ITEM 5.6 (b)

Issue/ Objection:
Car Parking

85 Harrington Street
The Rocks
GOLDEN AGE & HANNAS THE ROCKS

RESPONSE TO DoPE
ITEM 5.6 (b)

Plans
Basement Level 1

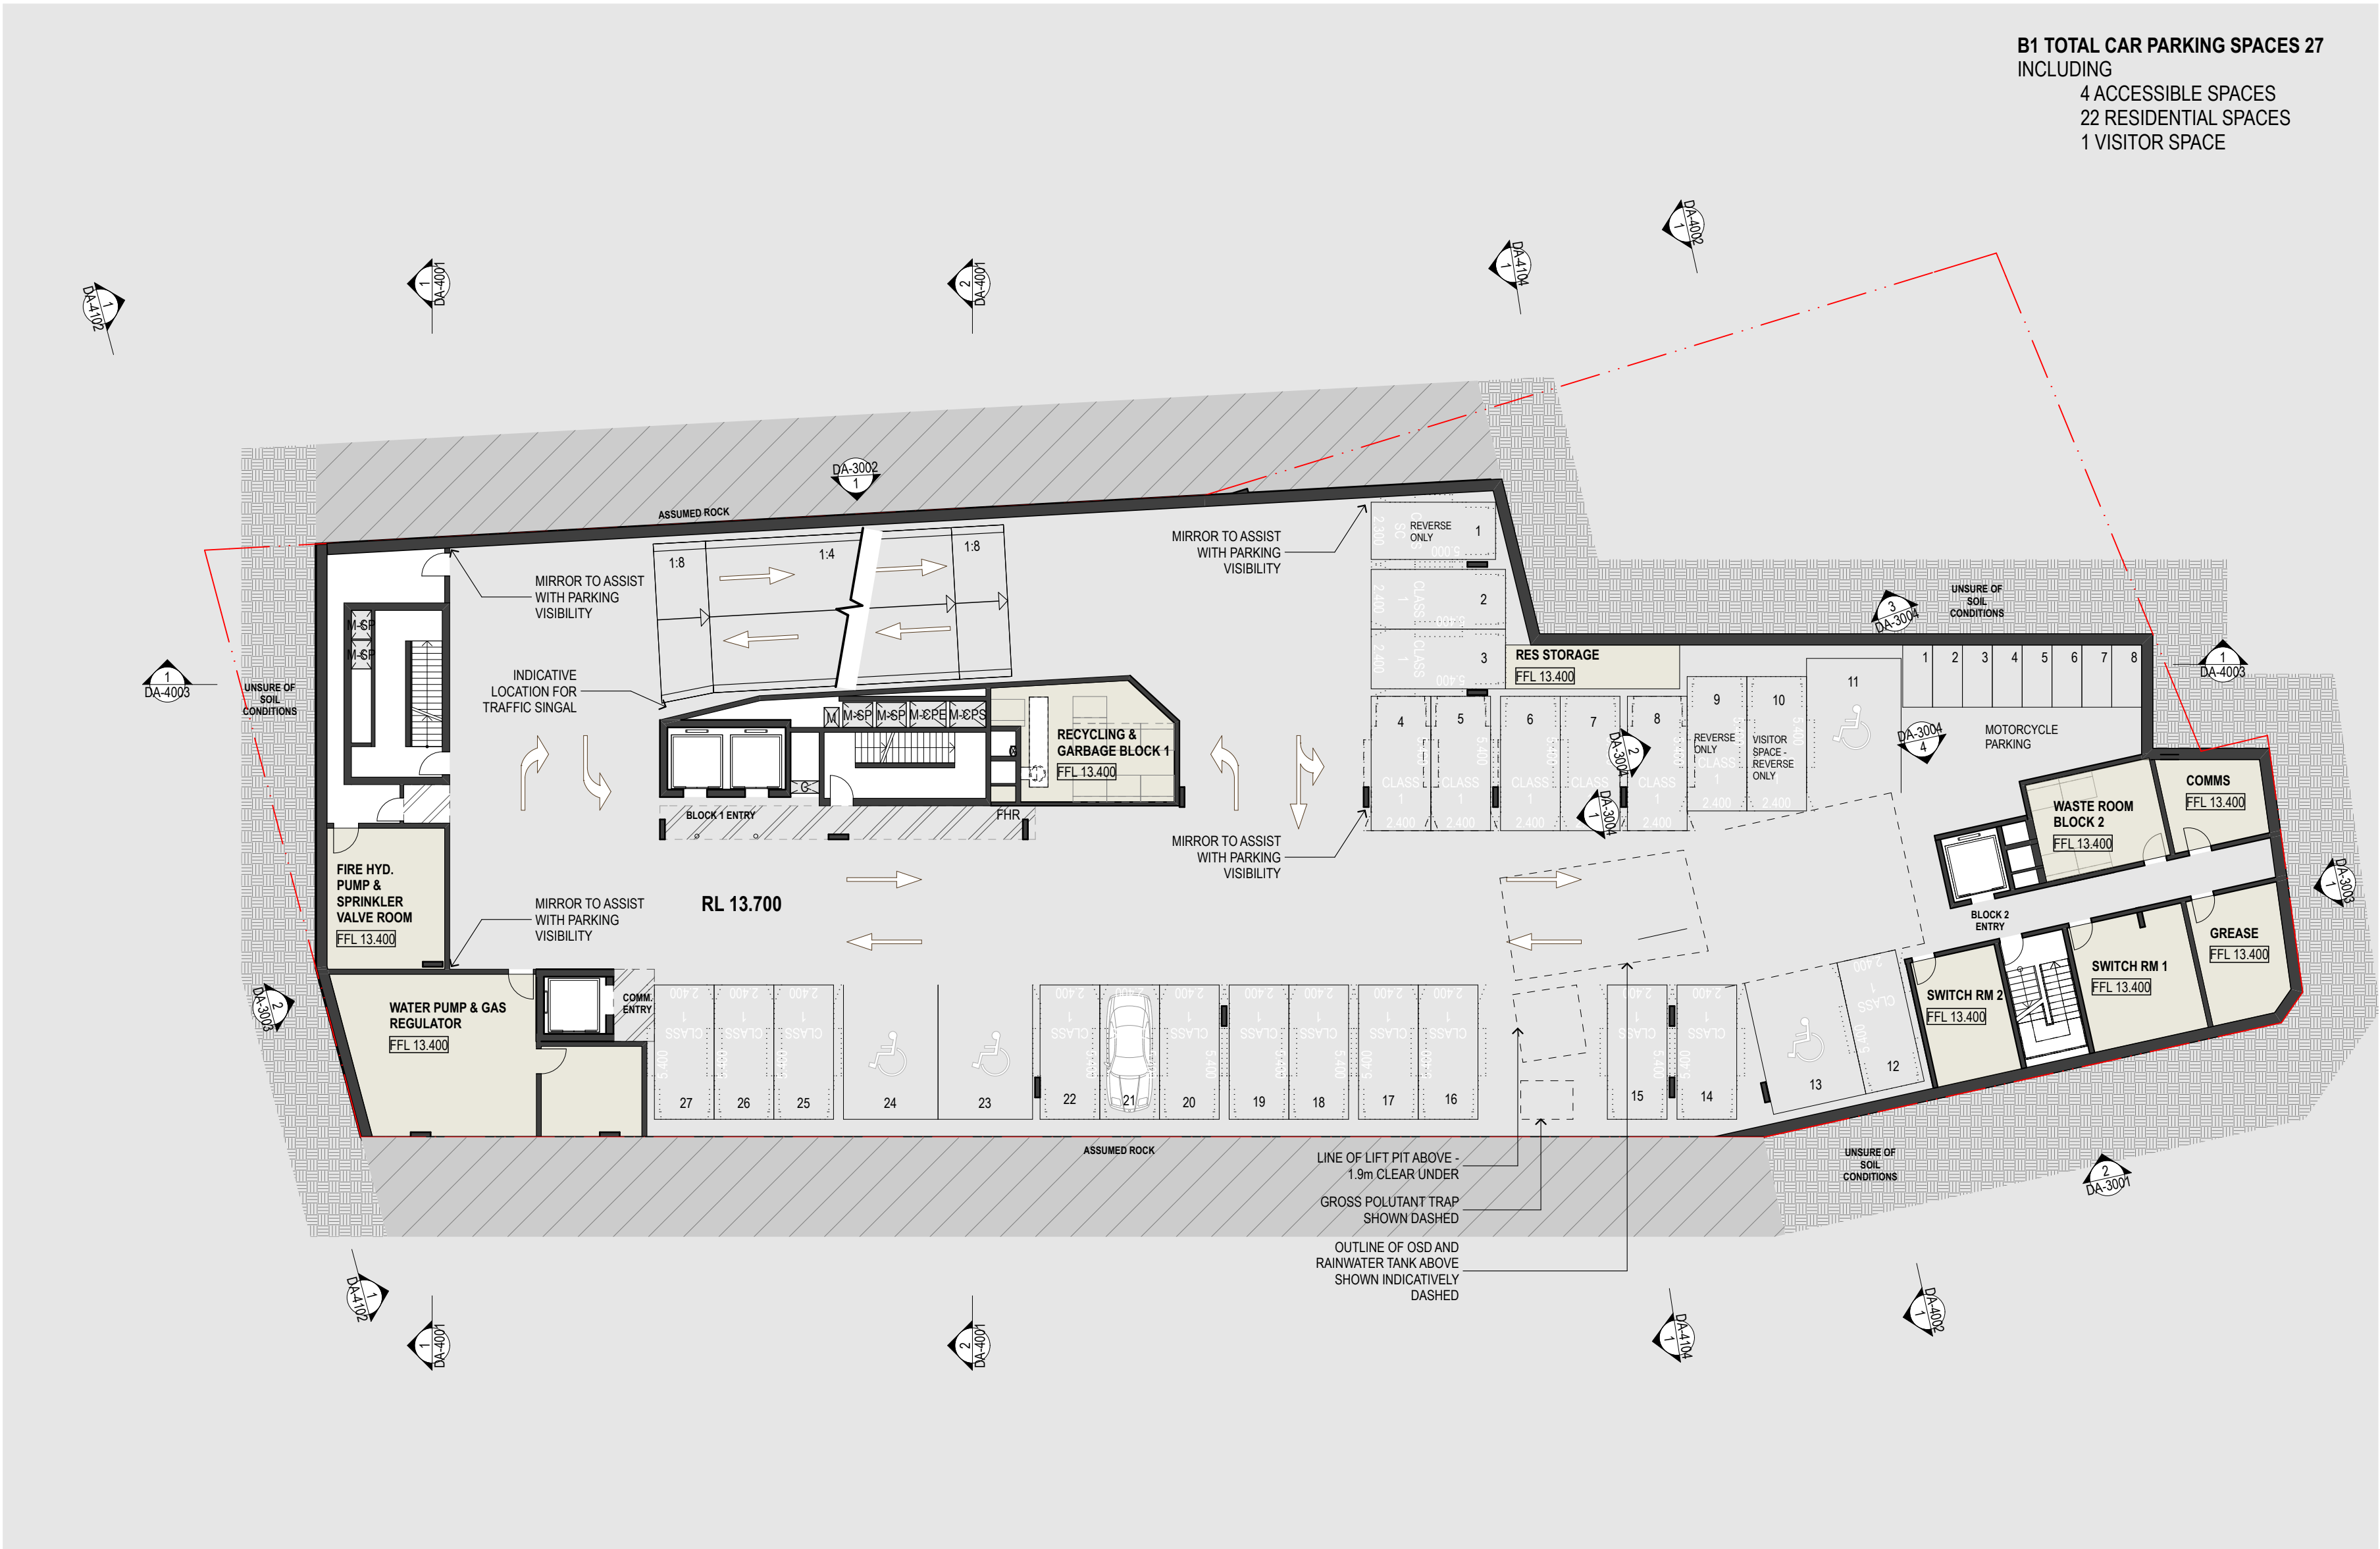
Description:
A review of car parking layout to demonstrate compliance with AS2890
Parking Facilities - refer to Council submission

Response
Bicycle parking has been provided at a rate of one (1) per unit within storage cages and 35
bicycle spaces for retail/commercial use, which is superior to the City of Sydney DCP
requirement. Refer to additional information provided by traffic consultant.
